Project Name:	Dearne Valley Parkway, Barnsley				
Client:	Gregory Property Group (GPG)				
Subject:	Response to Barnsley Highways Consultation Comments				
BGH Reference:	20-262-004.02				
Date:	05/09/2022				
Prepared by:	R. Donaldson	Checked by:	A. Bradley	Overview by:	M. Crabtree

Responses to BMBC August 2022 Consultation Comments

TWITTER, TWEET, RETWEET and the Twitter logo are trademarks of Twitter, Inc. or its affiliates.

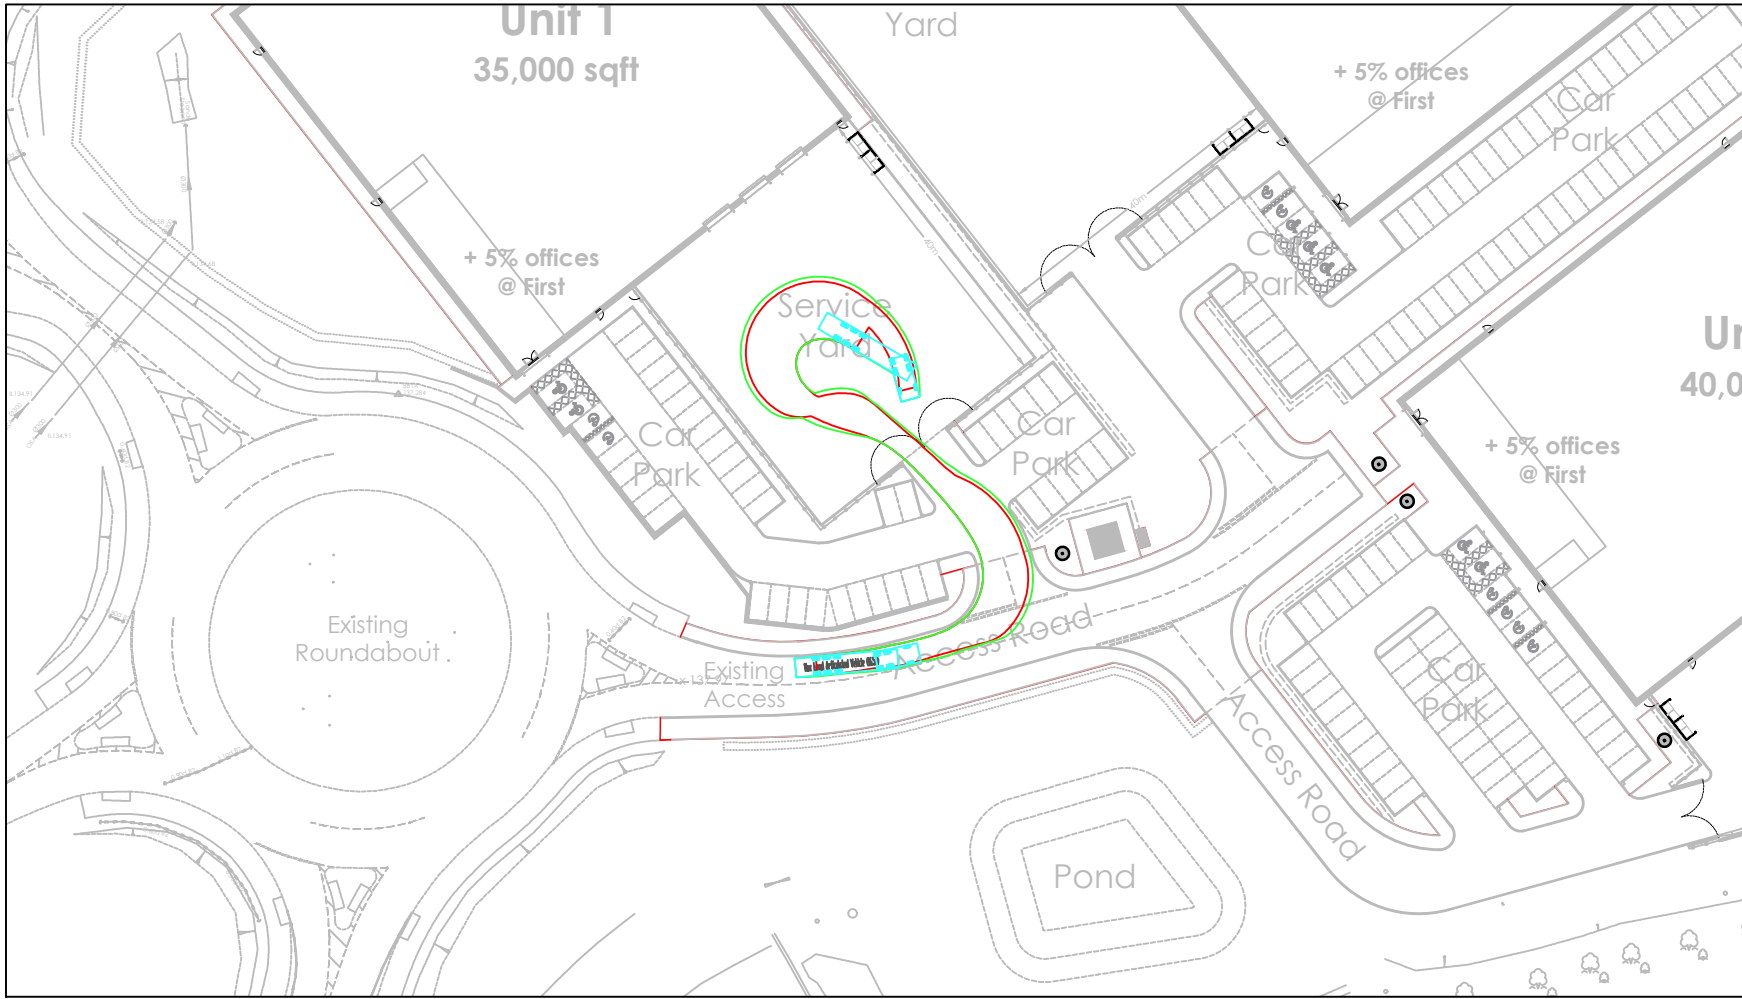
"The Transport Assessment appendix BGH 9 provides swept path analysis but will not be acceptable. A revised swept path analysis will be required that shows 2 x 16.5m articulated HGVs passing which should include a turning head."

7. Updated swept path analysis of the revised proposed site layout has been undertaken, which shows that a 16.5m articulated HGV can access the site and pass another HGV on the main site access road and the access road to Unit 3. The swept path analysis has been undertaken based on the proposed site layout with additional parking in the service yards, to demonstrate that there is sufficient room in the service yards for HGVs to manoeuvre with the additional parking in place. This is included at **Appendix BGH3** and can be summarised as follows:

- 20/262/TR/001 Rev C – swept path analysis of a 16.5m articulated HGV accessing and egressing the site using the existing roundabout junction with Sheffield Road;
- 20/262/TR/002 Rev C – shows that 16.5m articulated HGVs can access and egress each of the proposed plots;
- 20/262/TR/003 Rev B – shows that two 16.5m articulated HGVs can pass on the proposed Unit 3 access road;
- 20/262/TR/004 Rev B – shows that a 16.5m articulated HGV can manoeuvre within the proposed Unit 3 service yard;
- 20/262/TR/005 Rev B – shows that a 16.5m articulated HGV can manoeuvre within the proposed Unit 2 service yard;
- 20/262/TR/006 Rev B – shows that a 16.5m articulated HGV can manoeuvre within the proposed Unit 1 service yard; and
- 20/262/TR/007 Rev A – shows that two 16.5m articulated HGVs can pass each other on the main access road through the site.

8. HGVs will be able to turn within the proposed service yards, therefore a separate turning head is not required. Should any vehicles enter the site mistakenly, which is unlikely, they can either turn around within one of the proposed service yards or an alternative turning facility would be available using the accesses to Units 2 and 3.
